**WEST SUSSEX COUNTY COUNCIL
STRATEGIC PLANNING CONSULTATION**

**FROM: Debbie Farrell TO: Arun District Council
FAO: Mr J Baez**

SUBJECT: Proposed redevelopment of land to provide 13 new dwellings. Together with associated access, car parking, landscaping and retention of existing property.

PROPOSED SITE PLAN (1:200)

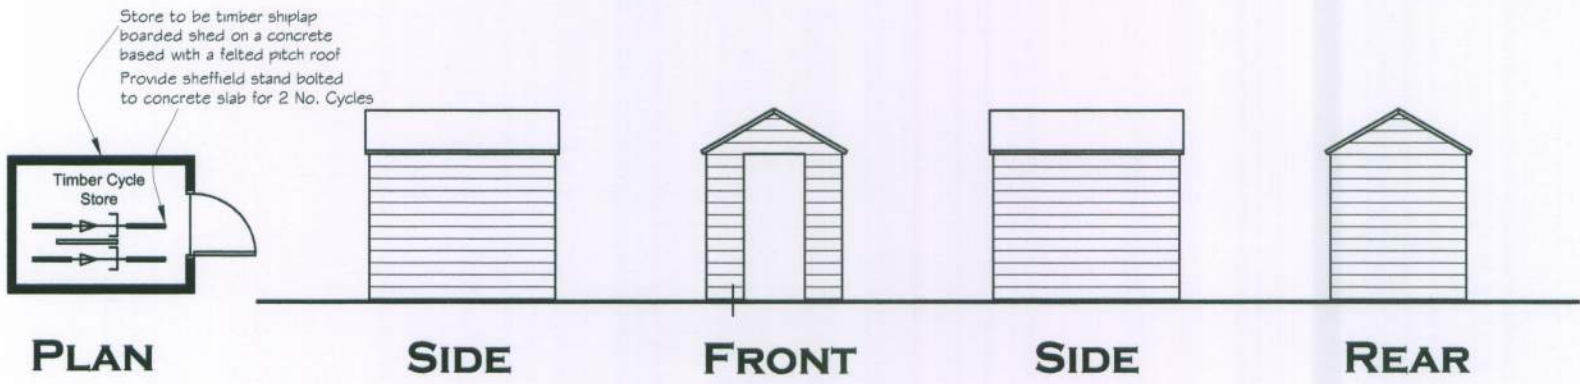
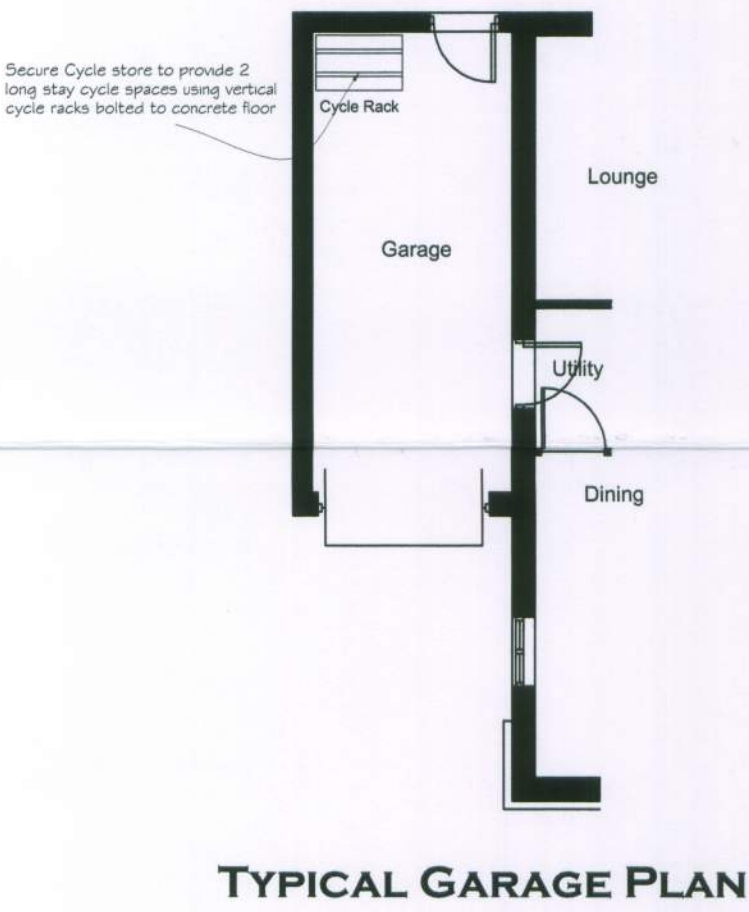
Visibility from the access is shown on the proposed site plan to be 40m in both directions, however in my view the achievable visibility at this location is over 100m on both directions. MfS states that visibility splays of 45m are required for a road where vehicles are travelling at 31mph. The applicant should show visibility splays of at least 45m on an updated plan. Alternatively, 45m visibility could be secured by condition.

The width of the access from Barnham Road is over 5m which will allow for 2 cars to pass and is acceptable to the Highway Authority. This width continues for approximately 20m before narrowing to 2.9m (for approx. 10m) adjacent to the existing dwelling, a margin of 0.5m between the edge of the carriageway and the building has been provided. No footpaths have been shown on the plans so it is assumed that the proposal is for a shared surface.

Vehicles are not likely to be travelling at high speeds along the access road it is also likely that pedestrian numbers will be low. However, I have concerns with the extent to which the road narrows. MfS states that the width of a family car is 2m and the space required by a single pedestrian is 0.75m and 0.9m for wheelchair users. In practise for a vehicle to pass a pedestrian safely additional space is required for manoeuvrability. In shared surface streets a margin should be provided in the event a pedestrian has to leave the carriageway to avoid a motorised vehicle. The margins provided of 0.5m are not adequate for this.

In addition, forward visibility is affected by the bends in the road. In the event a pedestrian is walking along the east side of the road s/he may be obscured by the existing dwelling and not seen by oncoming traffic.

I would therefore suggest that the narrowing is detrimental to the safety of non-motorised road users. However, it is appreciated that the road is not offered for adoption and would therefore not warrant an objection on Highway Safety grounds

A turning area has been provided to the north of the site and swept paths have demonstrated that a refuse vehicle can turn so as not to reverse onto the public highway.

A total of 37 car parking spaces and 26 cycle parking spaces have been provided which is acceptable. The cycle parking will need to be secure and covered.

The development, hereby approved, shall not be occupied until the car and lorry turning space has been provided and marked out, within the site, in accordance with local plan standards and a revised site plan to be submitted to and approved, in writing, by the planning authority. These spaces shall thereafter be retained at all times for their designated use.

No development shall be commenced until visibility splays of 2 metres by 45 metres have been provided at the centre of the proposed site vehicular access onto Barnham Road. These visibility splays shall thereafter be kept free of all obstructions over a height of 0.6 metre above adjoining carriageway level.
